ATTACHMENT 1 – Council Submission

SSD-76555711 - 3-5 Help Street, Chatswood

Drawing No.
 SSDA-1004

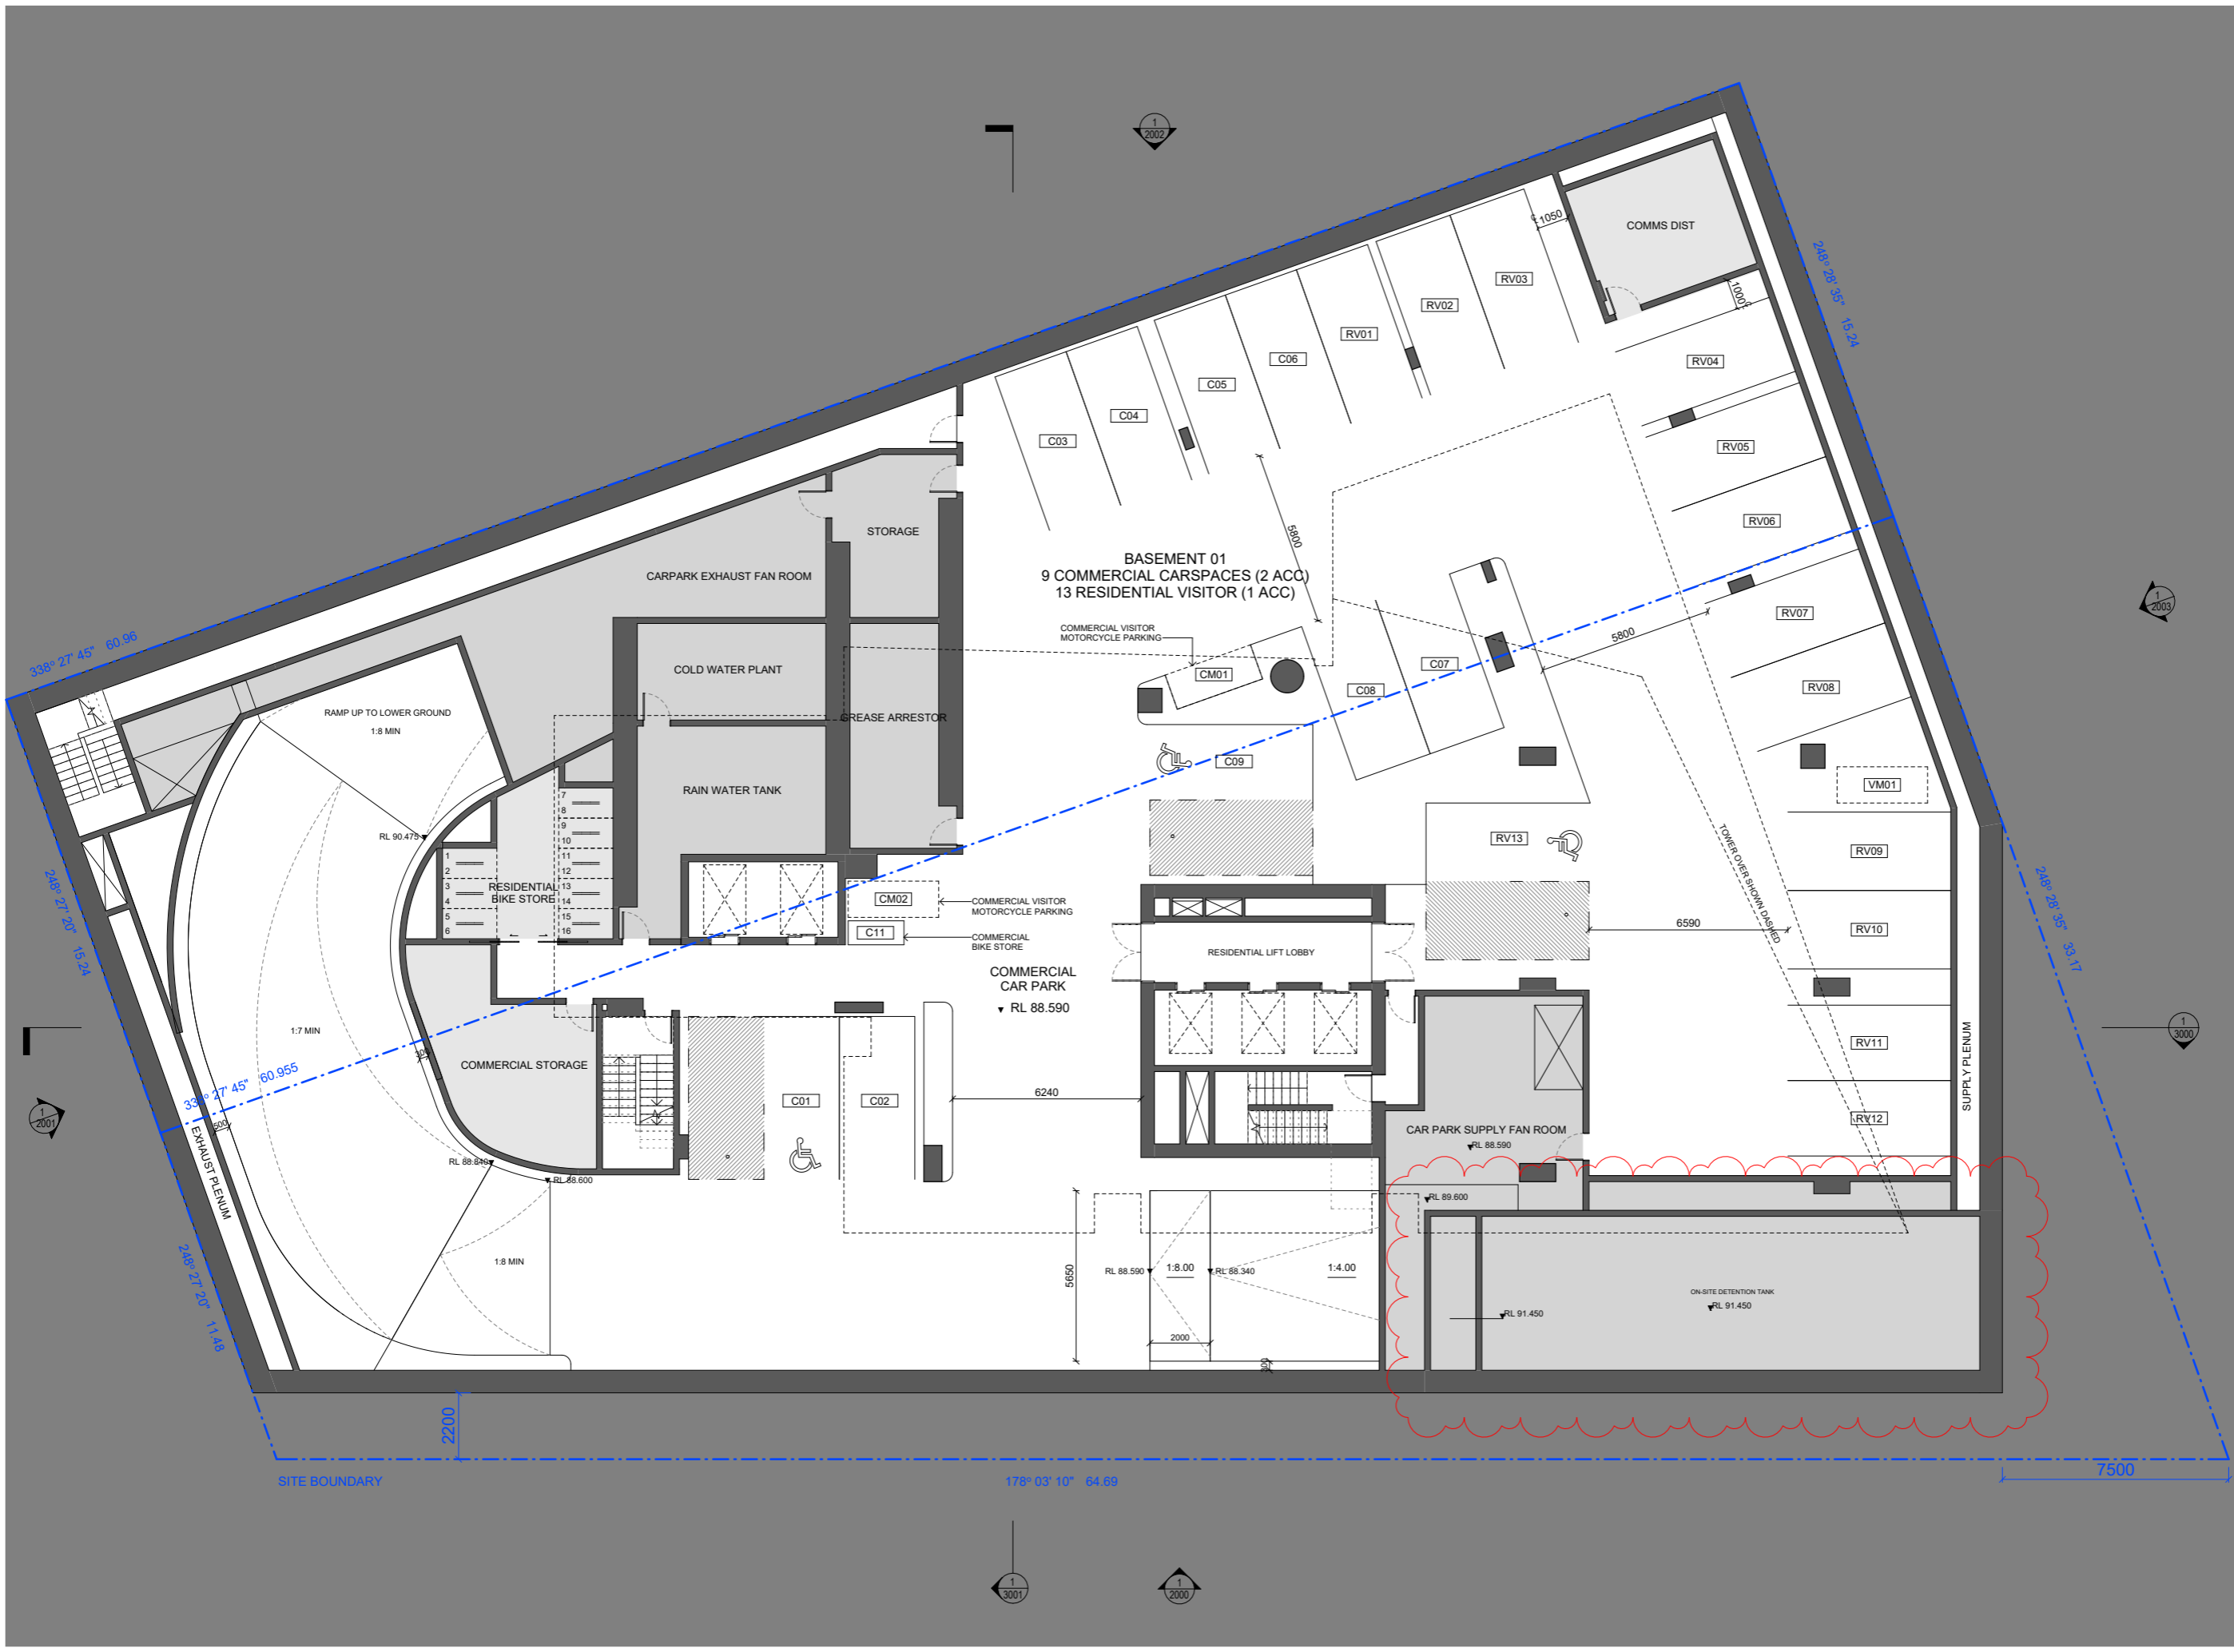
- There are two loading bays shown, an SRV bay and an MRV bay and no bays labelled HRV.
- There are discrepancies between plans in the length of the truck:
 - Public domain plan (EMBECE, Issue - 20.12.2024) shows an 8.8m truck.
 - LG plan (EMBECE, Issue C, 08.05.2025) shows a 10.5m truck.
- The MRV bay does not show a labelled 2m rear clearance.
- All bin rooms are not located with 2m of the truck parking space and the access to the residential waste holding room is limited due to the SRV bay location if the Council HRV stopped in the existing MRV bay.

In addition, it is not clearly shown how bins and bulky waste will be wheeled or carried around the truck with a 2m clearance for walkway (NSROC 2018, Section 3.16.2 Bin Carting Routes for caretakers and waste Collection Providers).

The loading area needs to be designed so that Council's HRV (10.5m long) has a 12.5m long parking space within 2m of each residential collection holding room (bins and bulky waste).
